CITY OF ALBUQUERQUE

**Re: Cosme retail (Central Ave)
6205 Central Ave. NW
Traffic Circulation Layout
Engineer's 10-22-16 (K11-D077)**

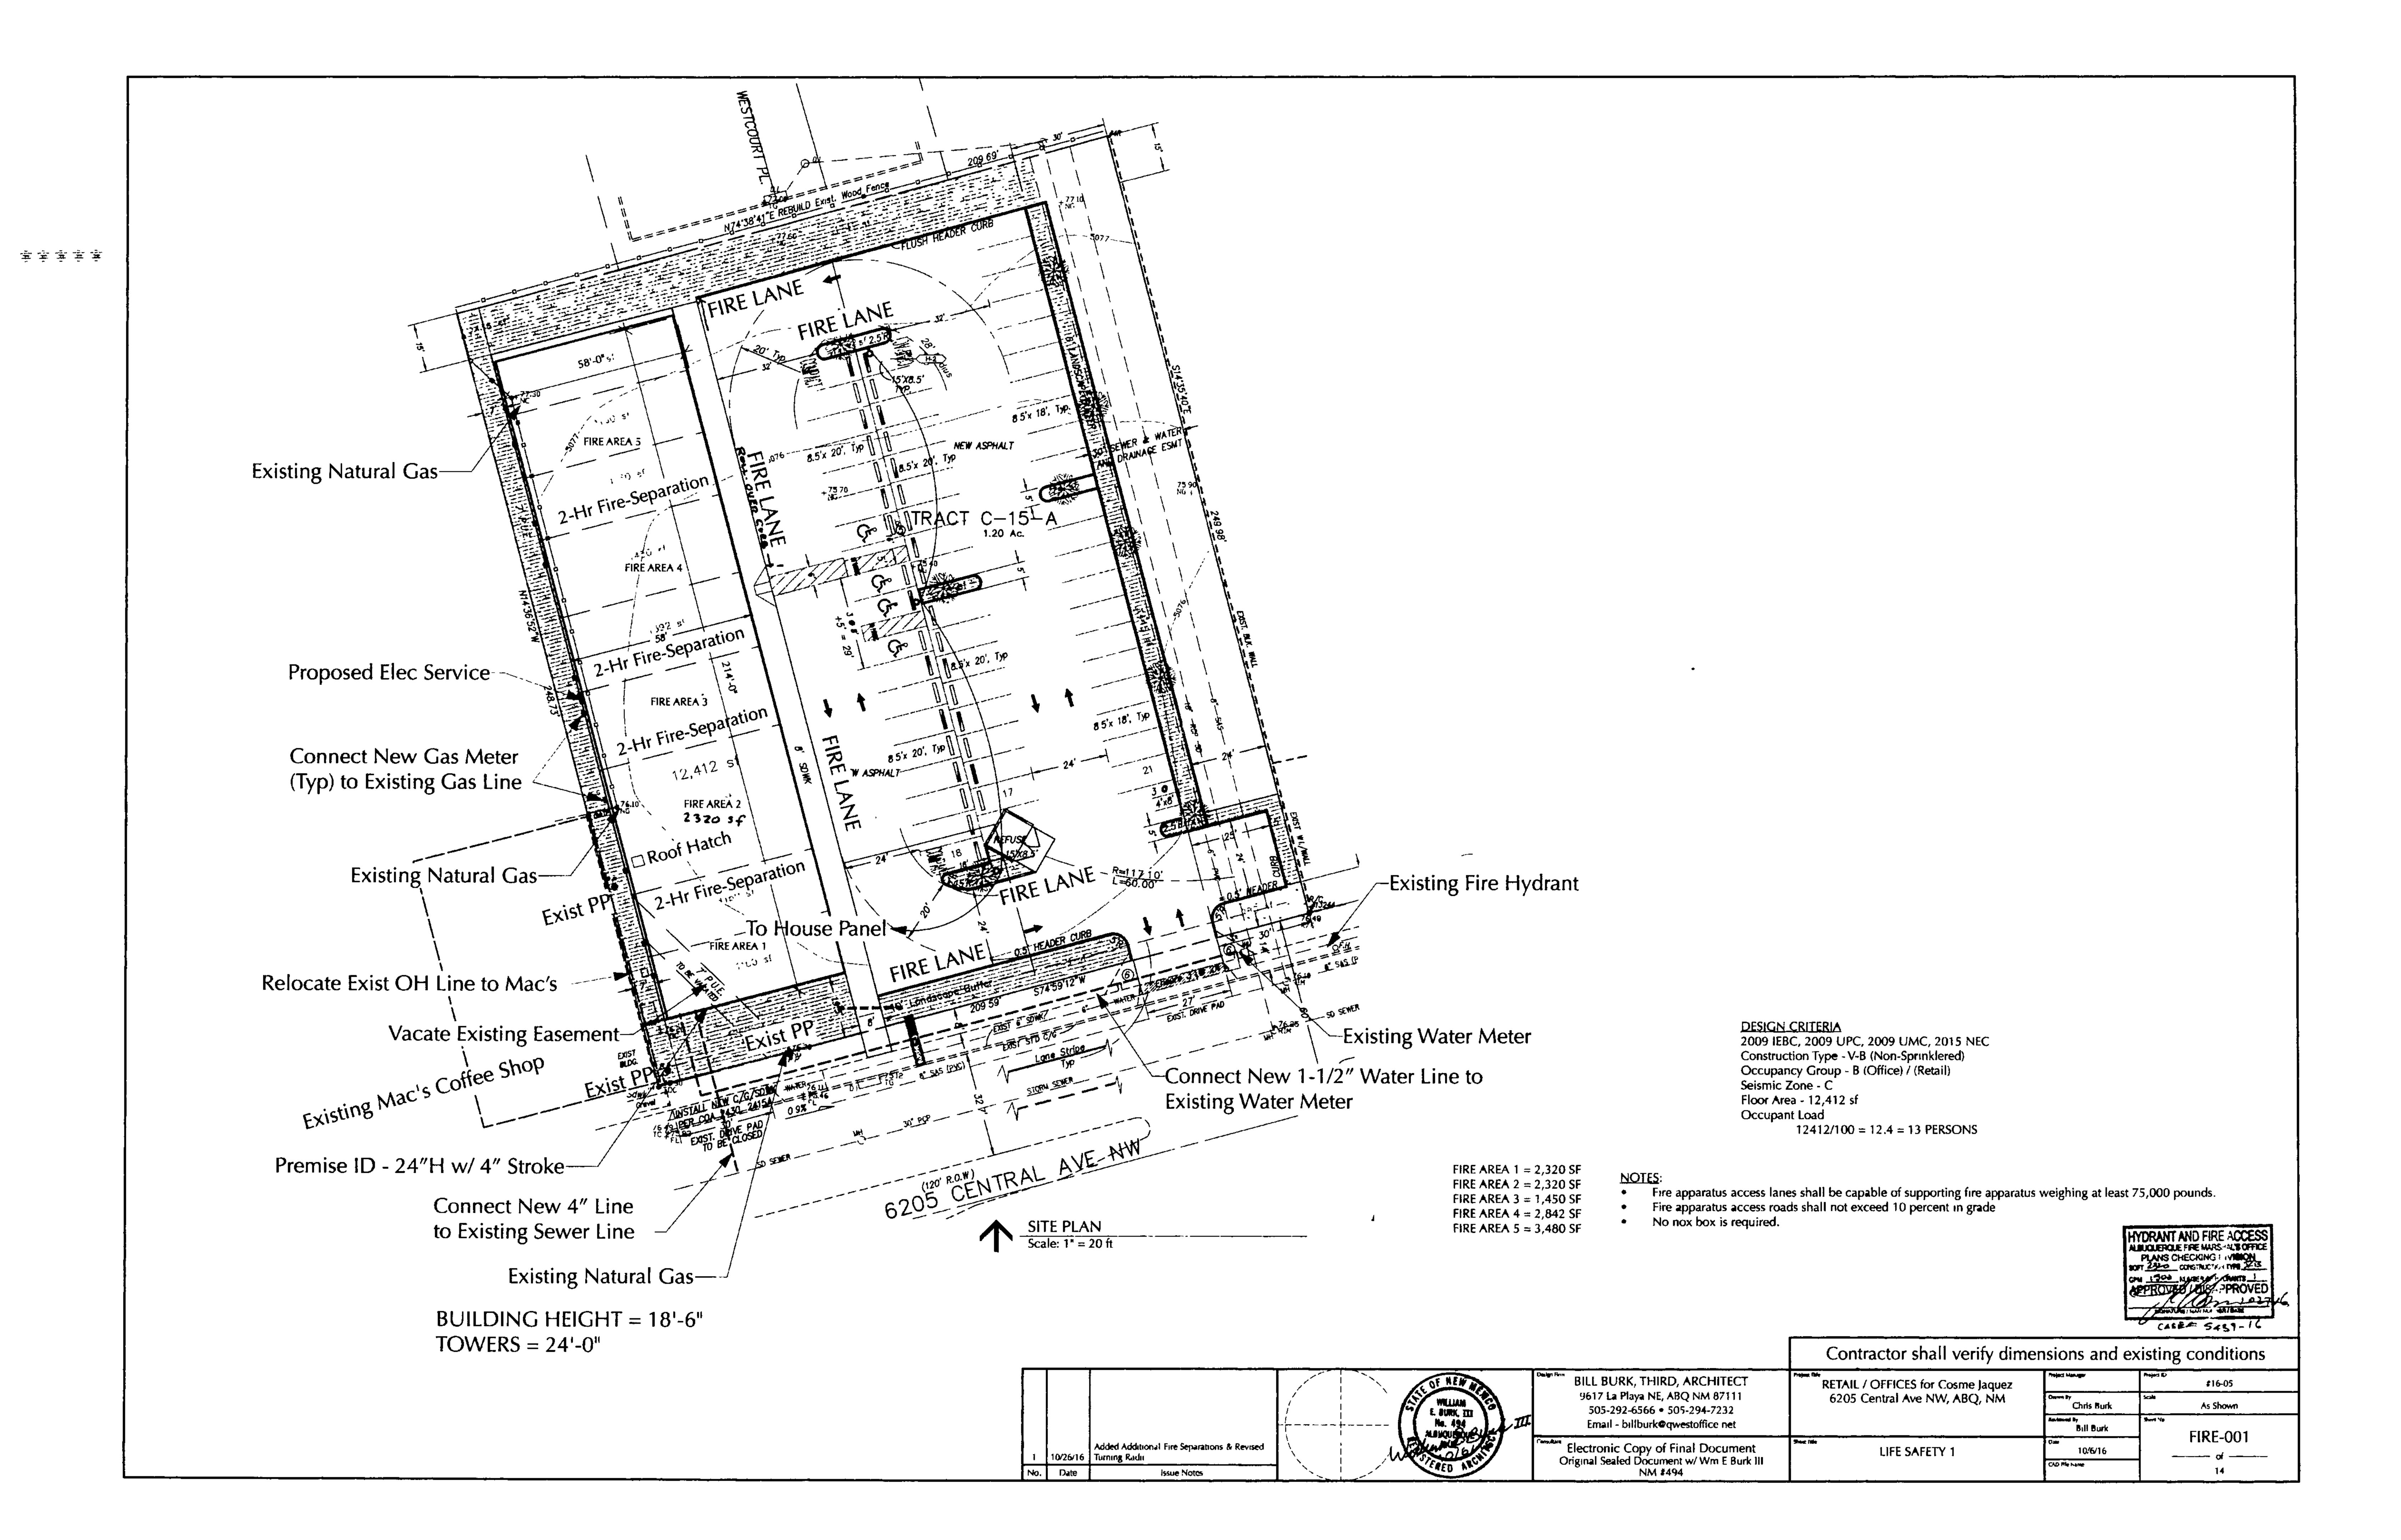
1. Please have zoning approve parking spaces required by the zoning code.
2. Please list the width and length for the proposed handicap parking spaces.
3. The ADA accessible parking sign must have the required language per 66-7-352.4C NMSA 1978 **"Violators Are Subject to a Fine and/or Towing."** Please call out detail and location of HC signs.

4. Show all drive aisle widths and radii. Some dimensions are not shown at the back of the parking lot.
5. The minimum end island radius for passenger vehicles is 15 ft. Radius for delivery trucks, fire trucks, etc. is 25 ft. or larger.

6. ADA accessible pedestrian pathway should not be placed behind parking space or adjacent to a vehicular way. Vehicle and pedestrian/wheel chair conflicts should be avoided as much as possible. Provide connectivity for both handicap aisle. (see attached drawing)

7. Will need to coordinate with ART PM Paula Dodge-Kwan (505) 768-3623.
8. Add striping and the words **"NO PARKING"** in capital letters, each of which shall be at least one foot high and at least two inches wide, to the refuse backing space.

9. Easements through proposed buildings must be vacated before TCL approval.
